107 India ASK-1 Top of wall Detail

Mon, May 2, 2016 at 12:14 PM

To: Ryan Senatore <ryan@senatorearchitecture.com>

ASK-1

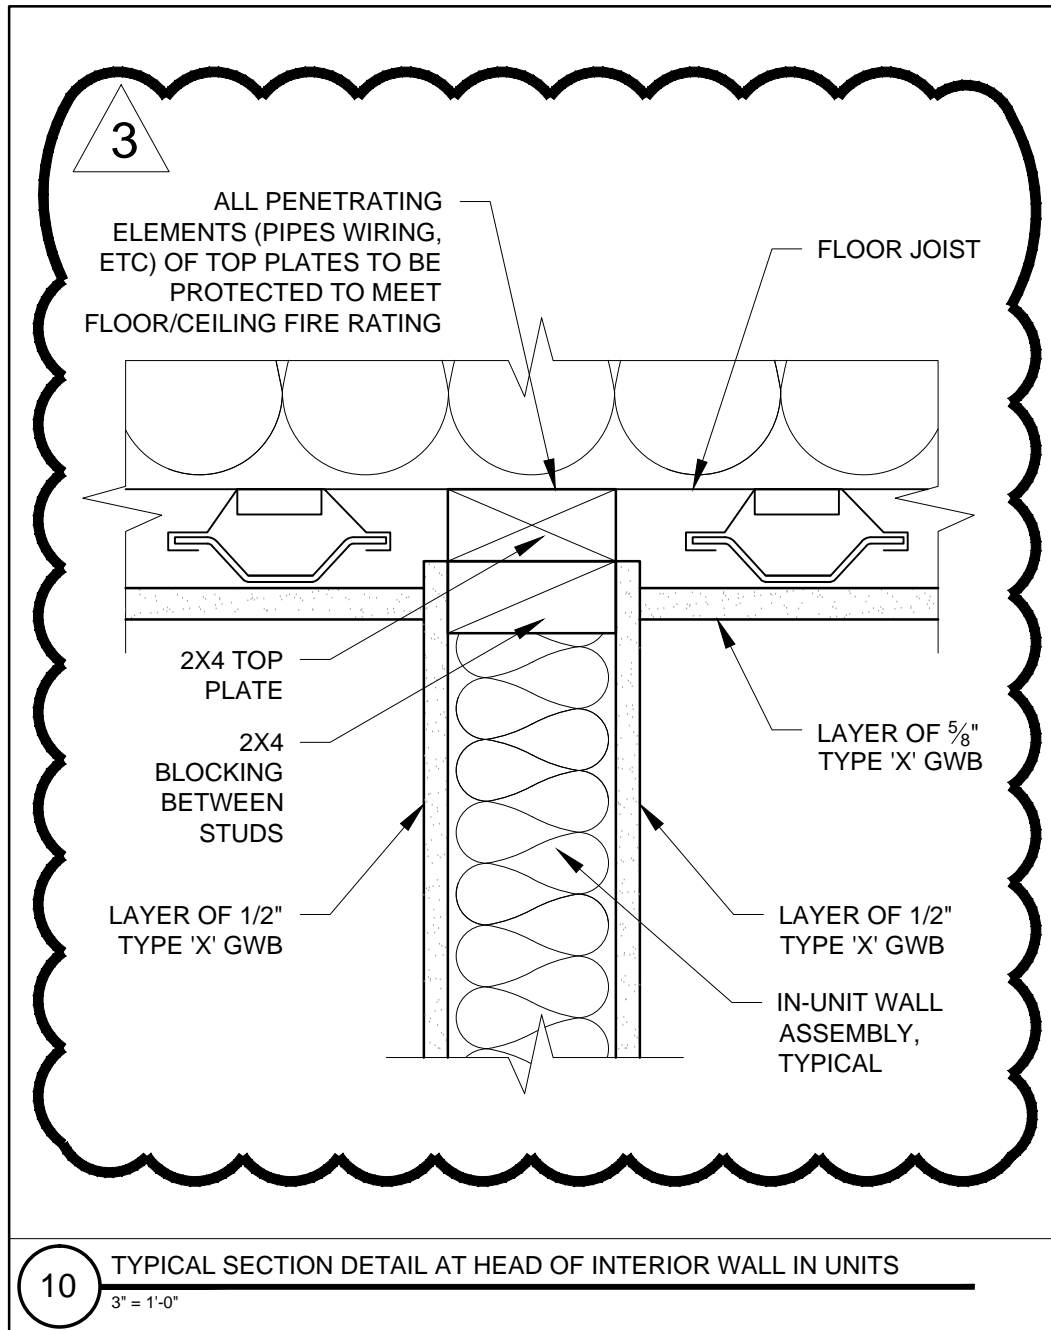
Thank you for sending this wall partition detail. It an acceptable method for maintaining the continuity of the rated horizontal assembly per Sec. 714.4.2 exception #7 of the 2015 IBC for membrane protection. This is approved per IBC Sec. 104.11 for alternative design methods, I will add this to the approved plans folder.

Let us know if you decided to contact the I-codes for further technical support on the prescriptive aspects of the wall plates in relation to the hourly rating of the floor/ceiling assembly.
